Planning Inspectorate

Our Ref: EN0110012

Date: 20 April 2026

Application by Light Valley Solar Limited for an order granting development consent for the Light Valley Solar project

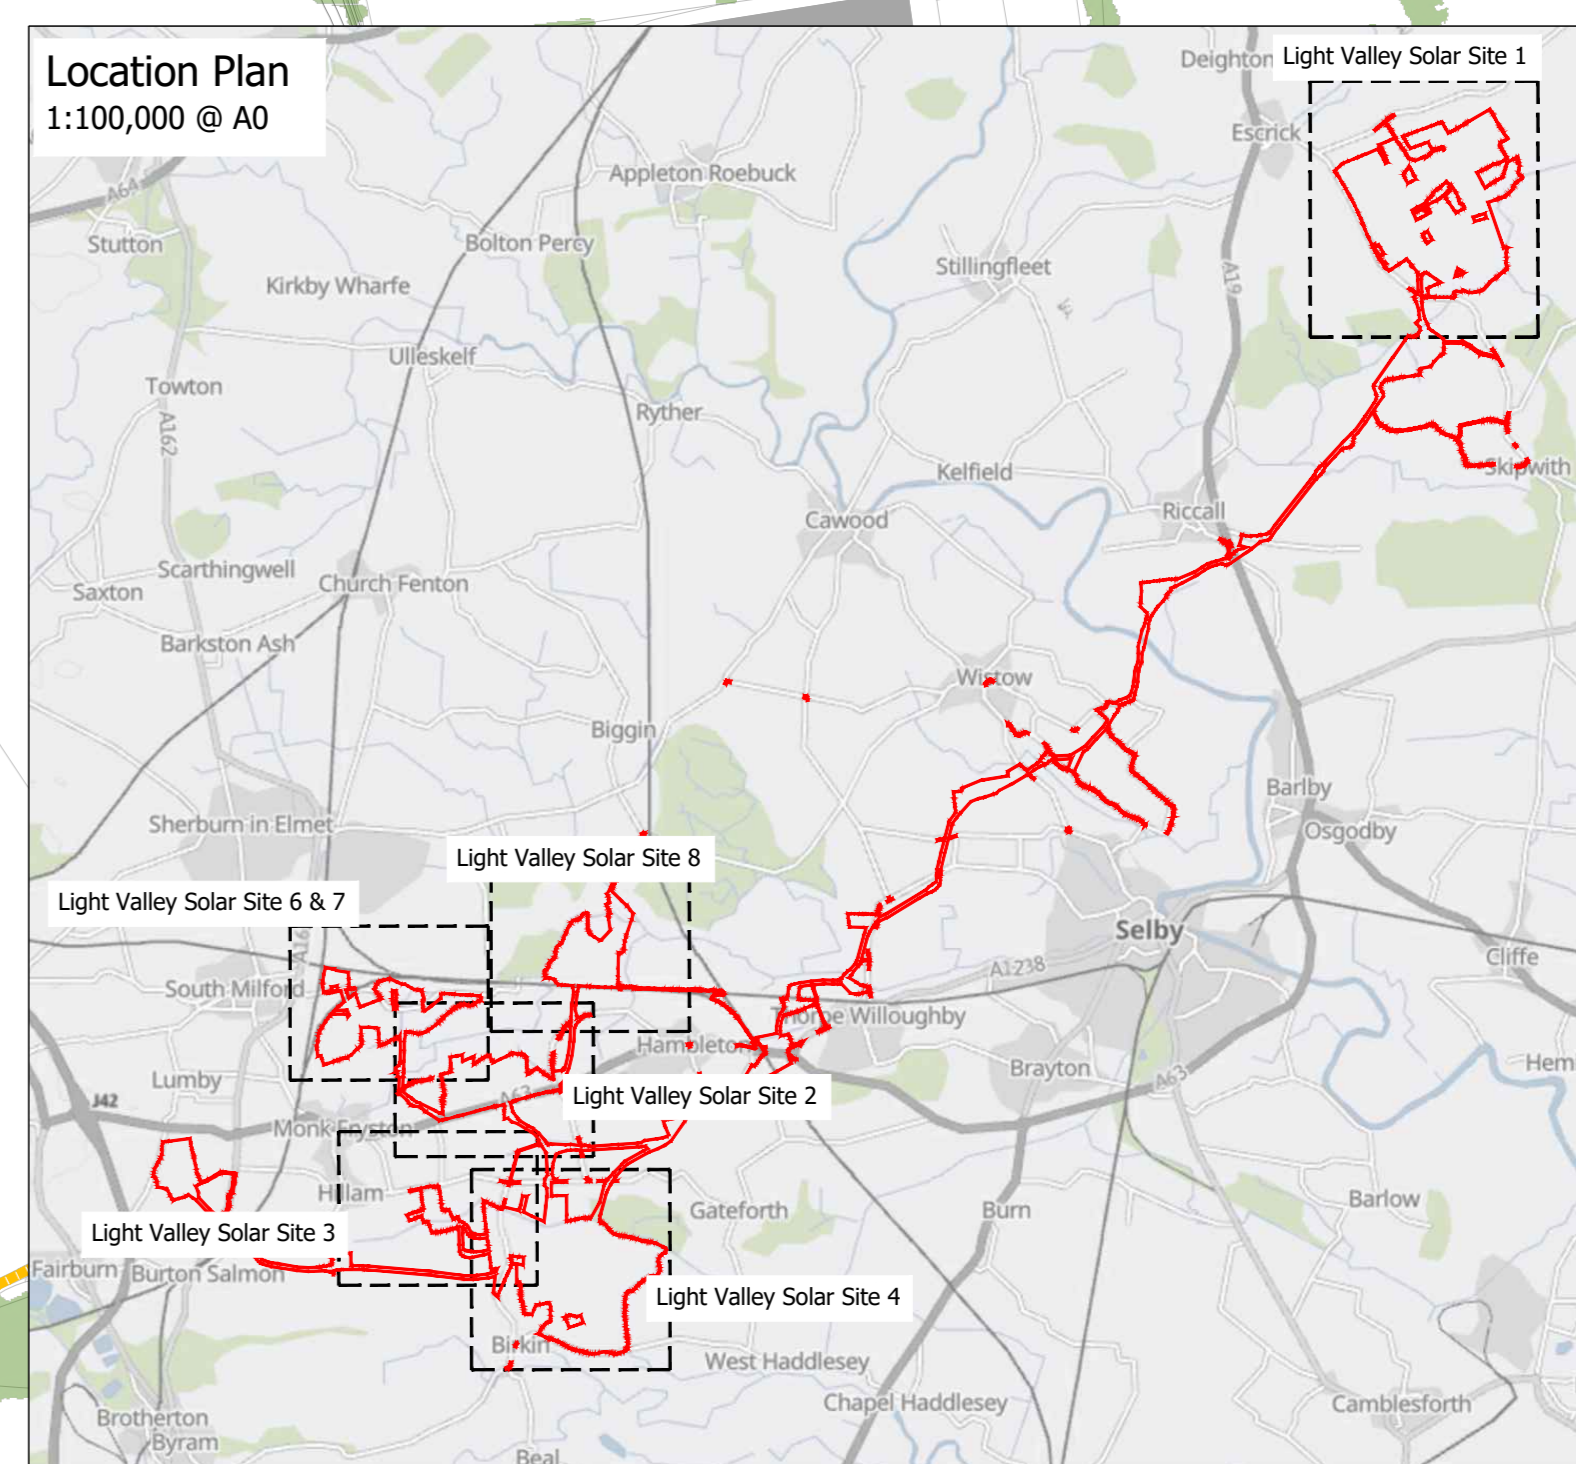
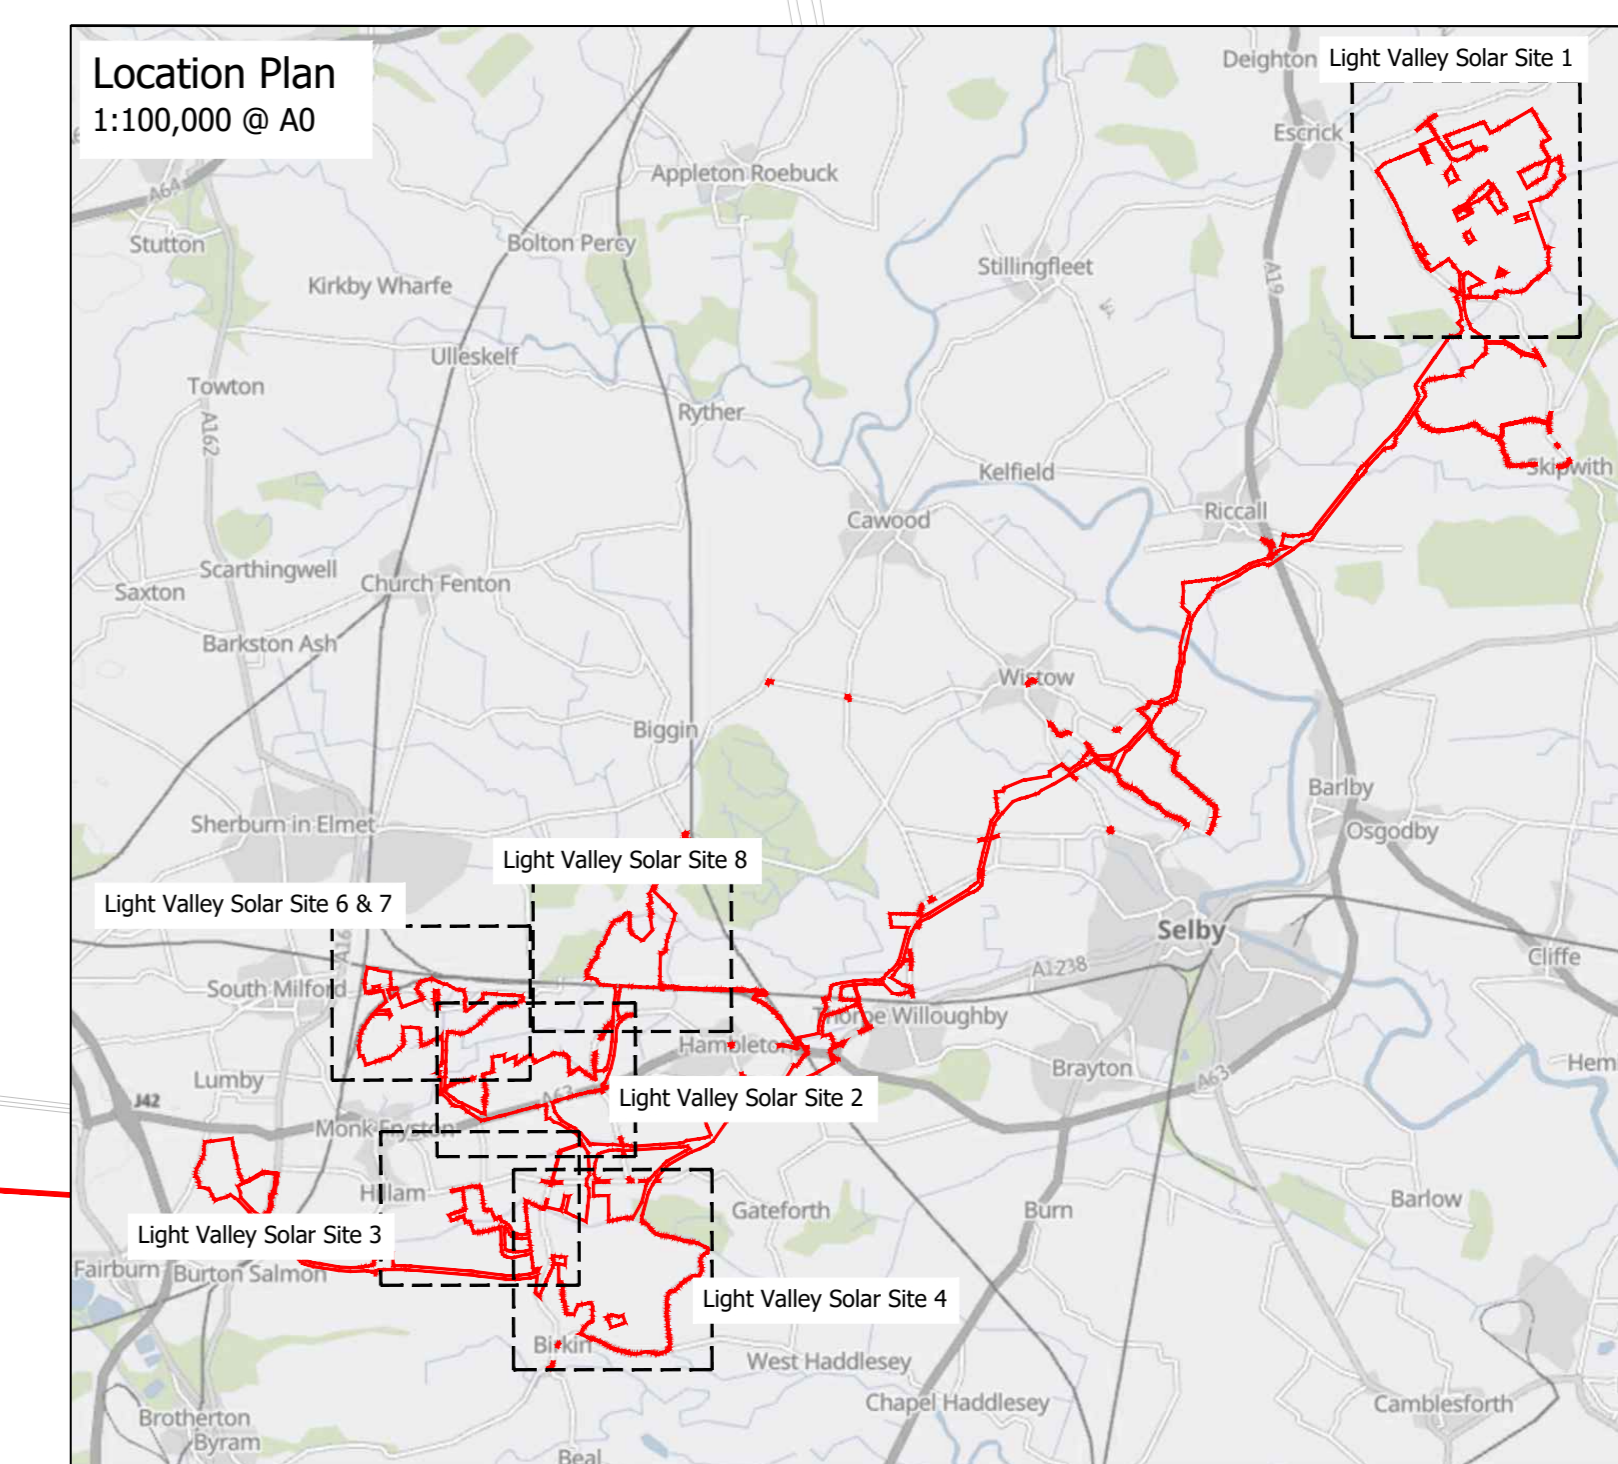
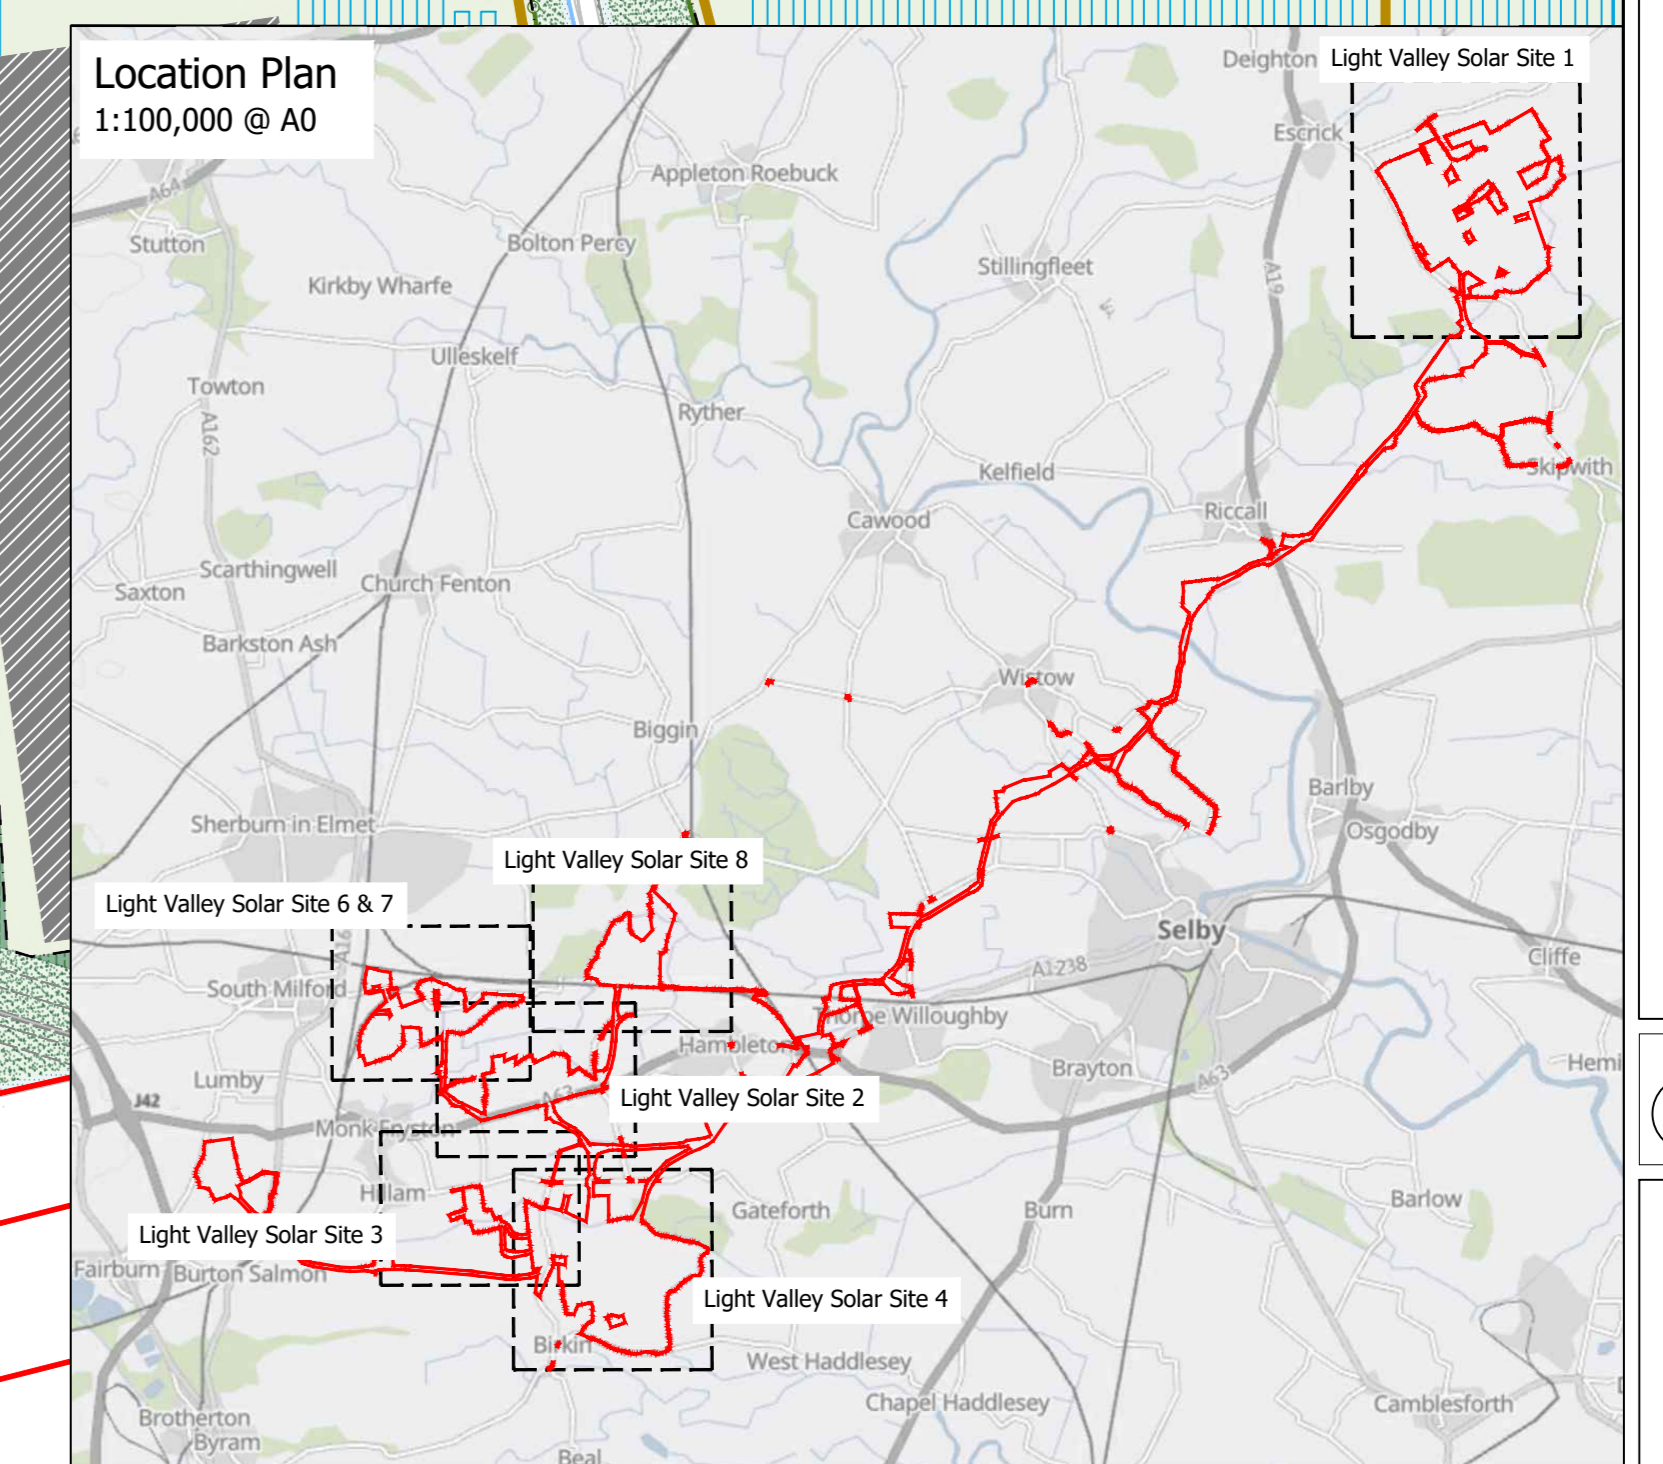
- 02.12.01 to 02.12.08 Outline Environmental Masterplans Site 1 to 8 due to continued lag and latency issues and lengthy file opening times experienced by the

Planning Inspectorate. These would be likely encountered by interested parties, affected persons, the ExA and others during the examination stage.

- **02.12 Outline Environmental Masterplan [APP-016]**– amended file/s of a standard that will enable multiple documents to be opened on a computer in good time and effectively used concurrently.
